Re: **Peak Technology Campus – Initial Review Comments – SWENT Comments added 1/29  
AR CP 18-00709-A3MJ20 & AR DP 20-00865**

The following list is to address each review comment made regarding the Concept Plan and Development Plan submittal review. The referral agency comments are in italics. Our response is in bold text.

SHEETS 16 SHEET 1

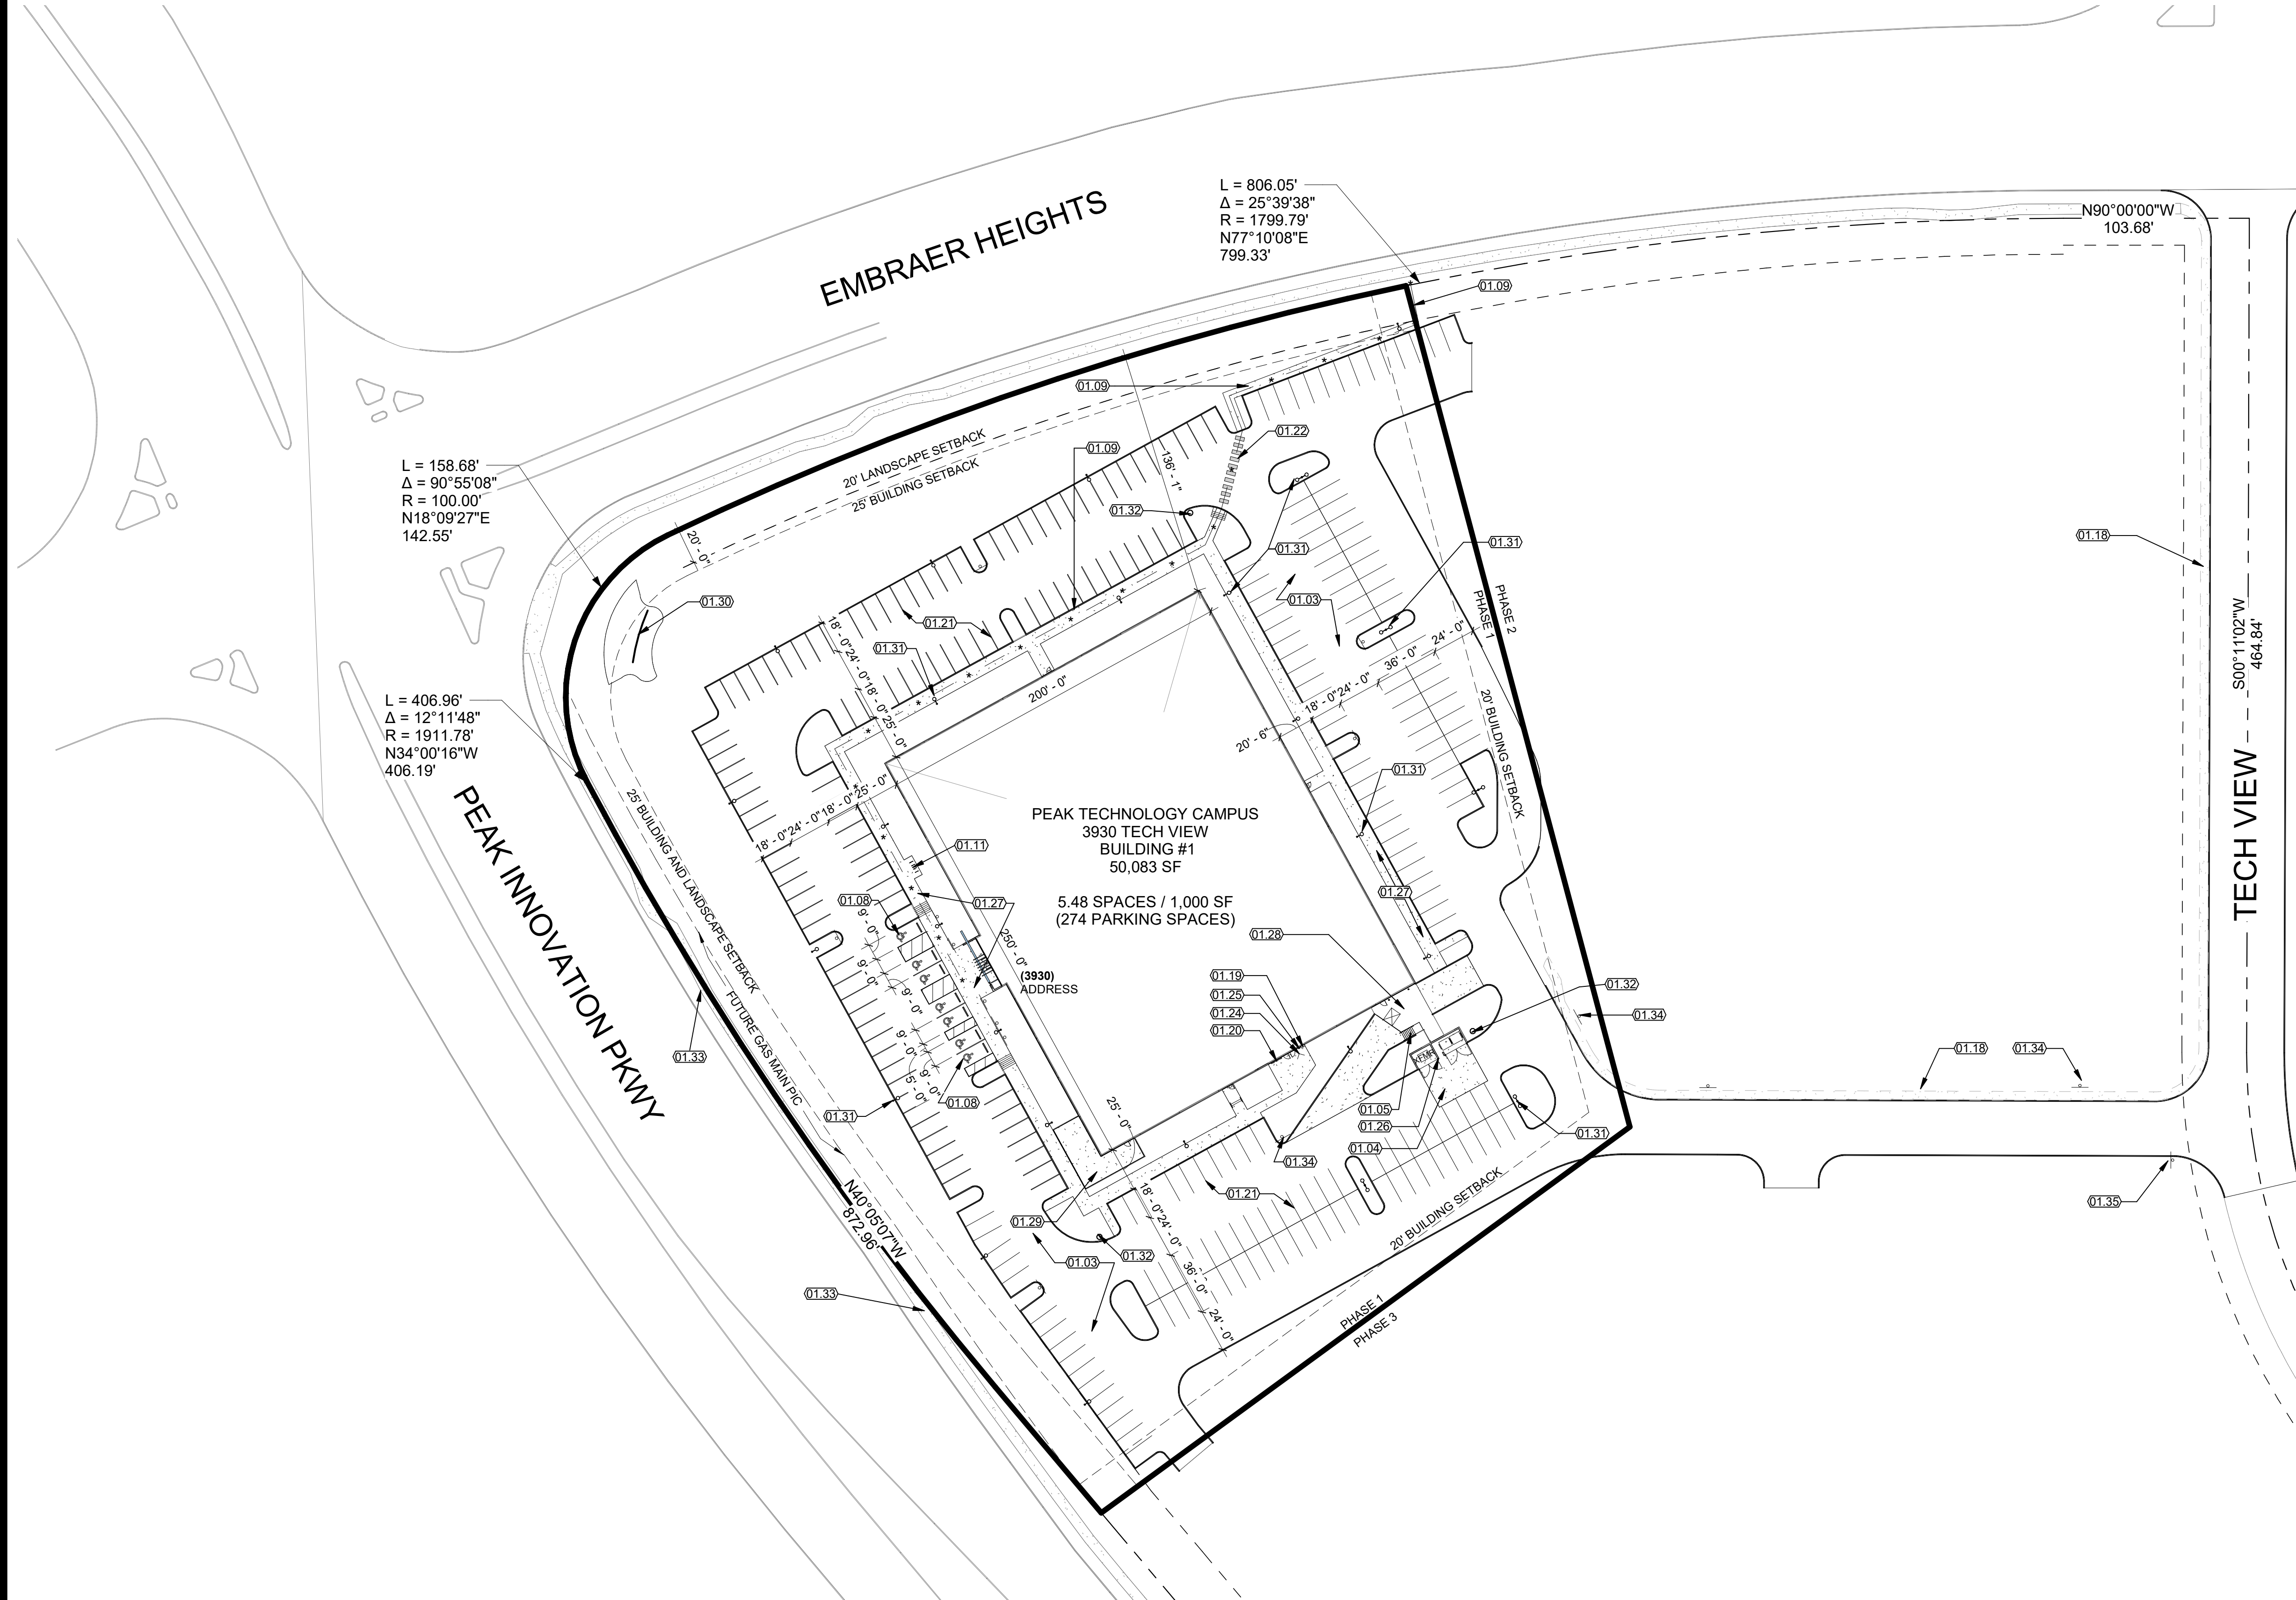
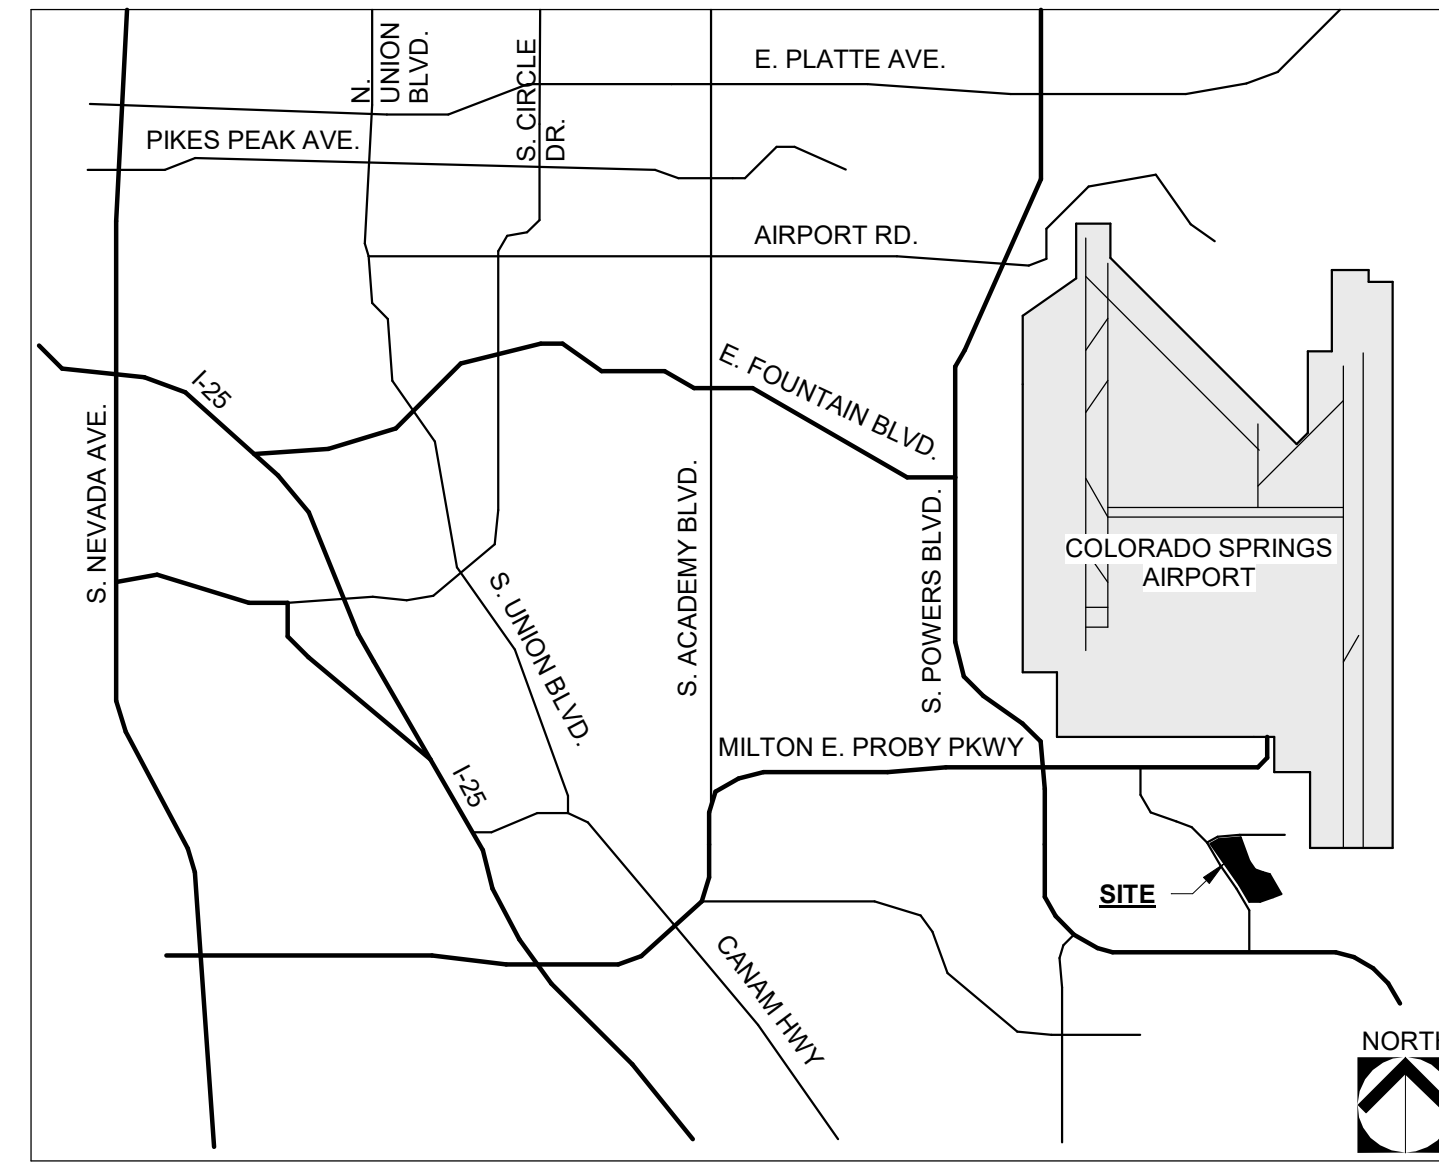
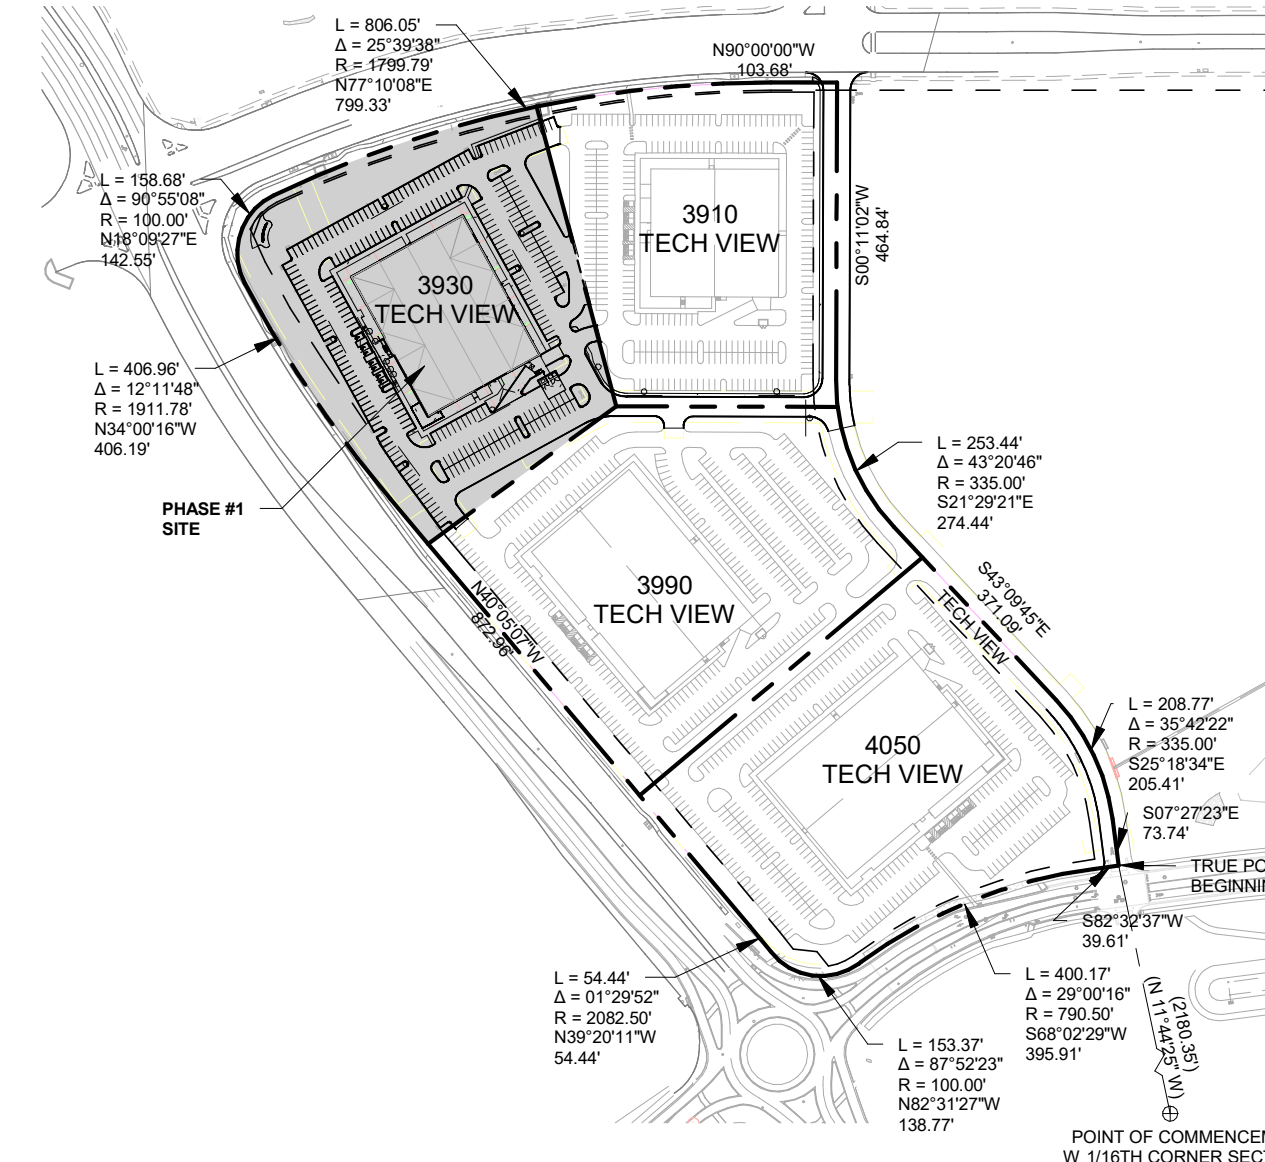
3. *Include a legal description that is only for the 5.78 acres that this development plan covers.*

4. *Under the development info section include “TSN – 5500000430” and “Address - \_\_\_\_\_”.*

10. *Update the concept plan file number on page 1 (AR CP 18-00709-A3MJ20).*

*installed by the Metro District. Please confirm if this would apply to this project. Staff will provide additional comments as needed. Currently the plans are showing that the onsite and ROW landscaping improvements and maintenance will be by the property owner. New Comment – Add the following note to the cover sheet: “The required ROW landscape and irrigation improvements along Embraer Heights and Peak Innovation Parkway will be submitted by the off-site improvement designer and approved by City Staff before any irrigation or landscape construction takes place.*

*Sheet 1:*

- *Note #5 last sentence, replace property owner with leasing developer.*

- *Note #12 There are two (2) number twelves, remove one.*

- *Note #13. Replace “concept plan” with “development plan”*

**Response:** A legal description of phase I has been added to the cover sheet along with the full parcel.

**Response:** We appreciate staff’s patience while the team worked through this comment with the airport staff. Airport has issued a name for the new street: Tech View, and an address is added to the cover sheet.

**Response:** Please reference updated Development Plan Sheet 1 of 16 which has been revised to reflect the updated concept plan file number as request.

**Response:** Please reference drawing sheet 1 of 16 which has been revised to include the ROW note requested as item 14 under “NOTES”. The master developer is requiring this project to provide design and installation of the landscape right of way. These plans represent this change.

**Response:** Revised as requested.

**Response:** Revised as requested.

**Response:** Revised as requested.
